Transcript of Uttlesford DC Reconvened Planning Committee - 17 March 2022 (Member Debate Only – not public/other speakers, or officer presentation)

Planning Application UTT/21/2137/FUL – Land north of Cornells Lane, Widdington

Drawing Title: **PROPOSED MEANS OF ACCESS**

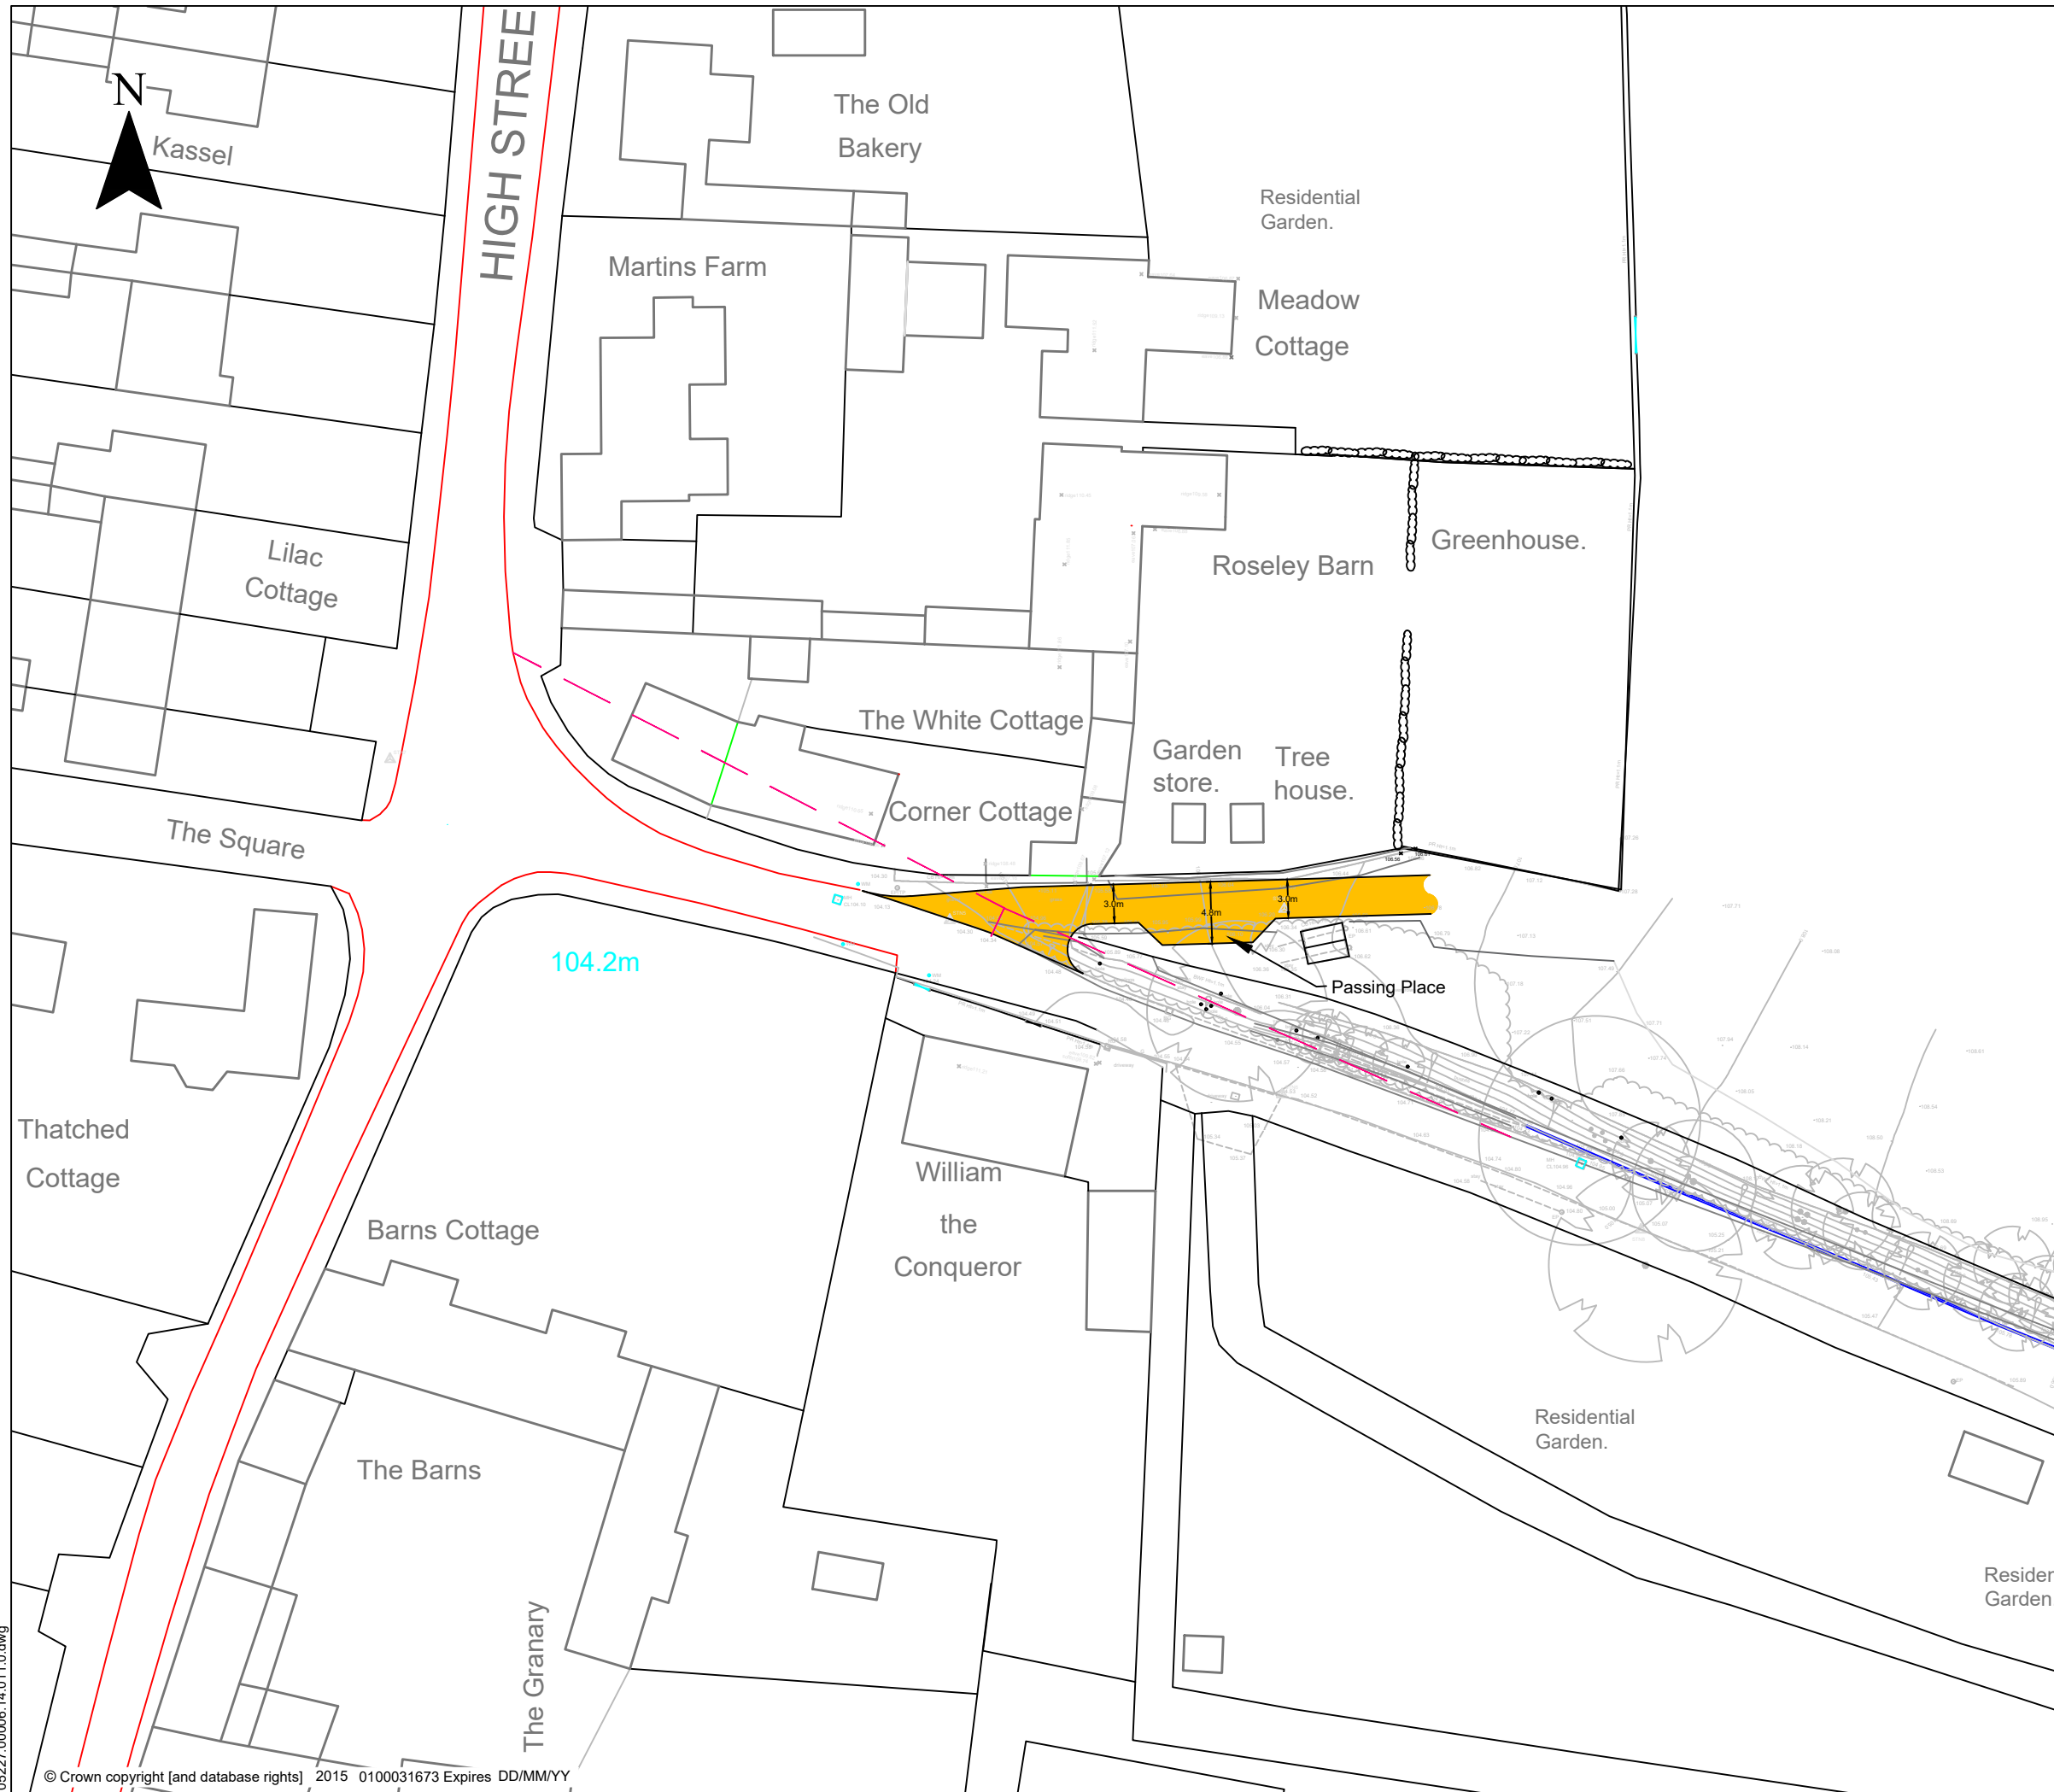
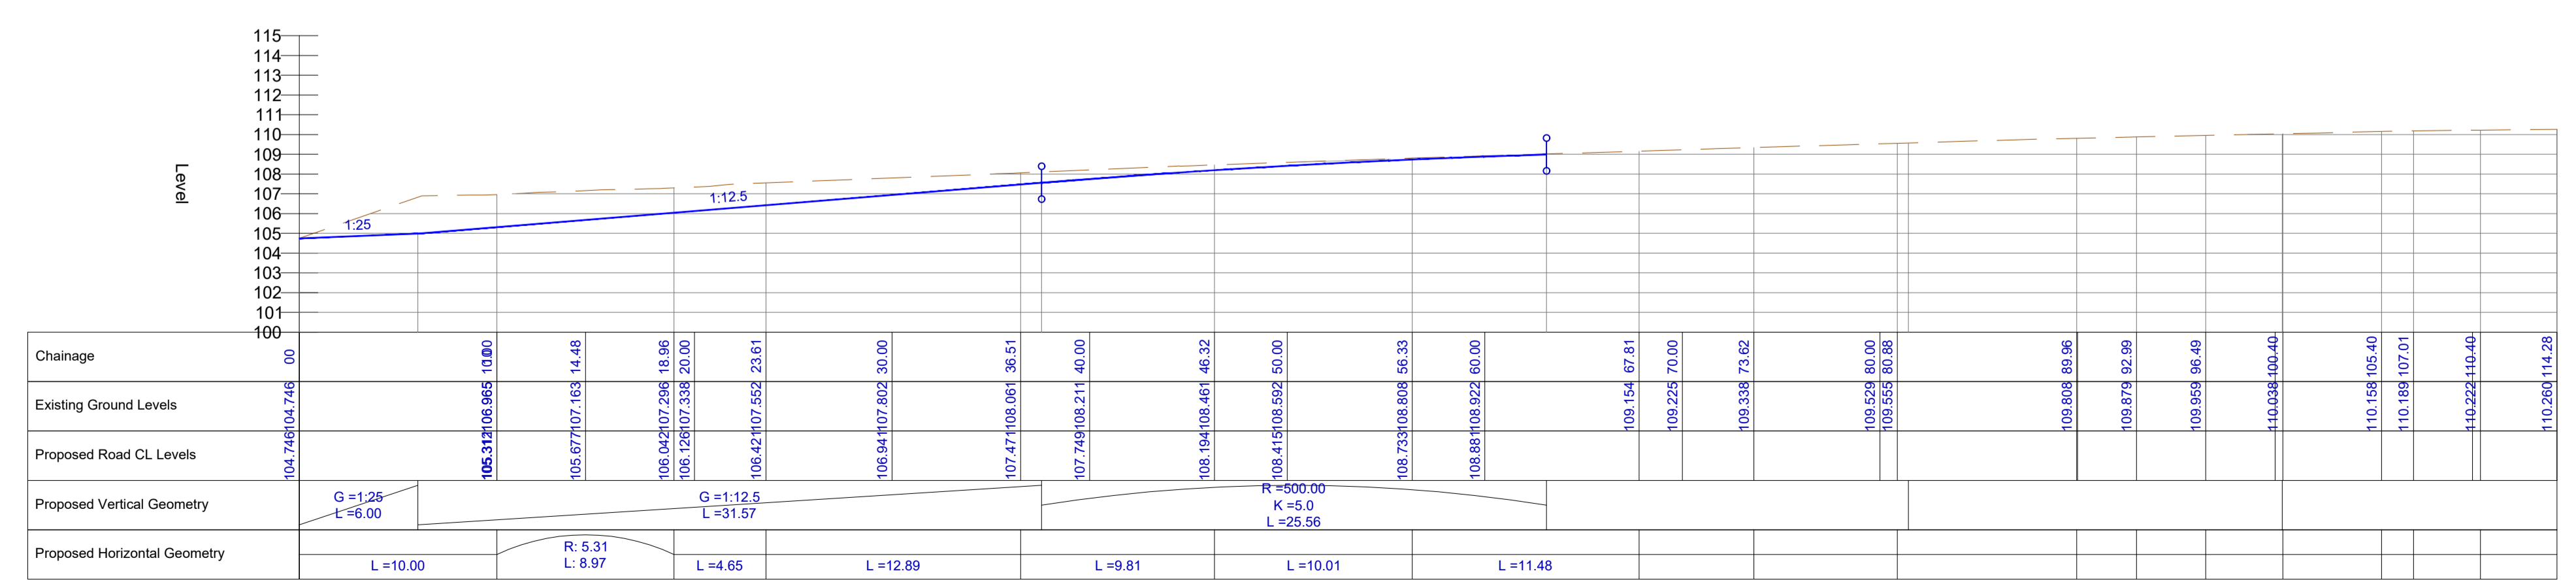
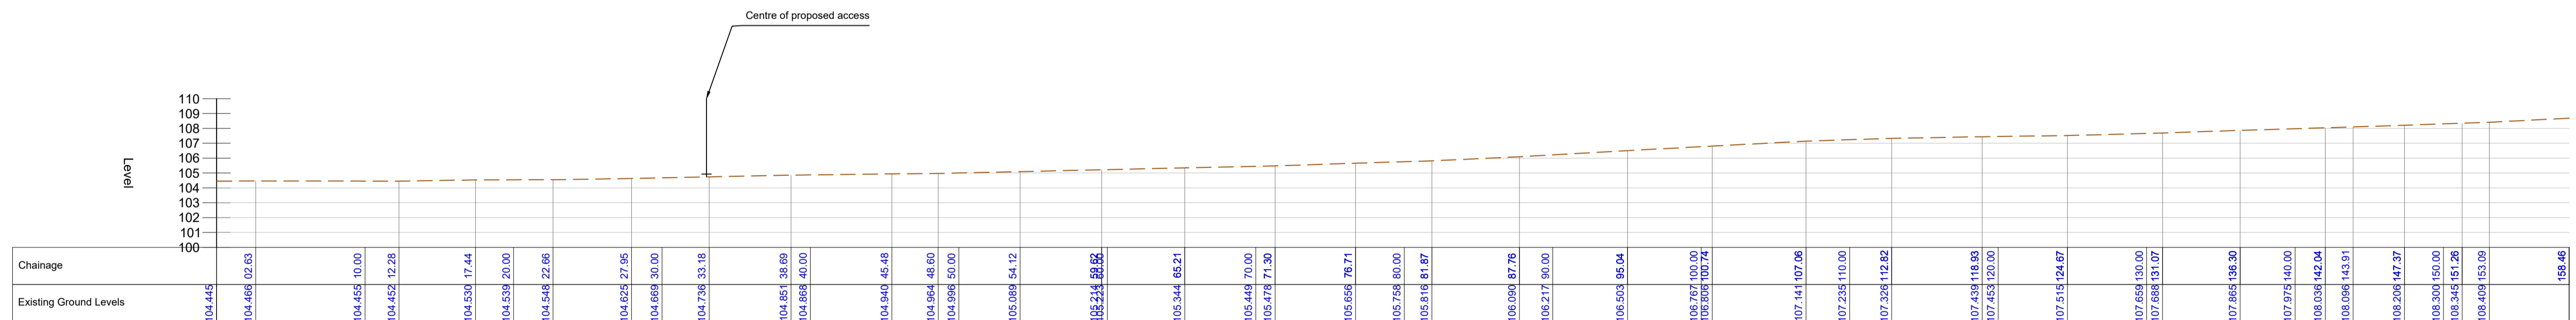
Can I, before I come onto somebody else, in, because we have these supplementals and 9.60, is the highways and there's a red, in the red writing, in the red print, it says there are some minor changes to the gradient, which Essex highways, Essex County Council Highways seek by condition 1.15, the highway's consultant confirms this can be complied with. Now 1.15 says this is starting to get technical, so my brain starts to get a bit, I'm not really good on gradients and thinking of percentages and things. So somebody might, I might have to ask the officers to try and help me with this. The gradient of the proposed vehicular access shall not be steeper than 4%. That's one in 25 for the first six metres from the highway boundary and not steeper than 8%, which is one in 25 thereafter. Sorry, not 25, sorry one in 12.5, thank you very much. Helping me out there, thereafter, to ensure the vehicles can enter and leave the highway in a controlled manner in the interest of highway safety. That to me still seems quite steep. Can somebody help me with that please?

I just had a further point. I'm looking back, I'm just looking at the, the Railton report, which was the, independent, transport assessment, assessed, produced by, on behalf of the parish council, forms appendix one of their submission, so he specifically mentions that, the gradient that's proposed is contrary to Essex design guide design details that states for all junctions, the approach gradient should be no steeper than 2.5% within 10 metres at the junction. So he goes on to say, well, even if it's, was it 4% you said, if it's been...

And then 8% after, he said, the difference in levels could be, so he said there's not, there's not any information about, well it's unclear how the difference in levels between the access road and the dwelling could be achieved without some significant regrading the Western end of the site. Difference in levels could be accommodated either through the introduction of retaining walls or by the introduction of embankments. A retaining wall with the height of 4.7 meters, or 1.9 meters to 2 metres if gradient standards were met adjacent to Cornells Lane would both dramatically urbanise the street environment and creates a stark canyon feature that would constitute an extremely dangerous environment for pedestrians. For safety reasons, it's likely that any retaining wall would need to be set back from the edge of the carriageway. And this would have the effect of increasing the scale of the access and the impact from the surrounding embankment, trees and vegetation. I think in the absence of any information about how that's to be achieved, it's very difficult to not just visualise it, but to actually assess the degree of harm that might be done. And I think that's, I'm surprised that highways haven't insisted on knowing that information before determining whether that's actually a safe and suitable access.

I think almost whatever the access looks like, it's going to urbanise the site. And, I saw in one of the responses that the, the width of the access would actually be wider than Cornells Lane itself, which it just seems to me in an inappropriately urban form of development for what is it pristine rural environment right now. As you said, the benefit of the scheme is four houses, but there, there is, there are identified harms identified by an inspector, not just by our opinion or by our view and by the conservation officer. And we have concerns raised by, an independent transport consultant, you know, that counters the view and actually Essex highways' view is contrary to their own guidance. You know, that what they've said is acceptable is contrary to what the regulations actually say. I mean, the regulations say that you can have exceptions, but there hasn't been a

Now, I think there are other harms here, which have been identified by the appeal inspector to heritage and character and the appearance of the area that I don't think we can ignore. And, I'm not comfortable saying that all of those matters are okay, as long as we can sort out the access, because I think the harm to the protected lane, it will be harmed regardless of whether the access is, you know, a two and a half gradient or, or 4% or 8%. A big chunk of it will be removed, that green canopy won't be there anymore.
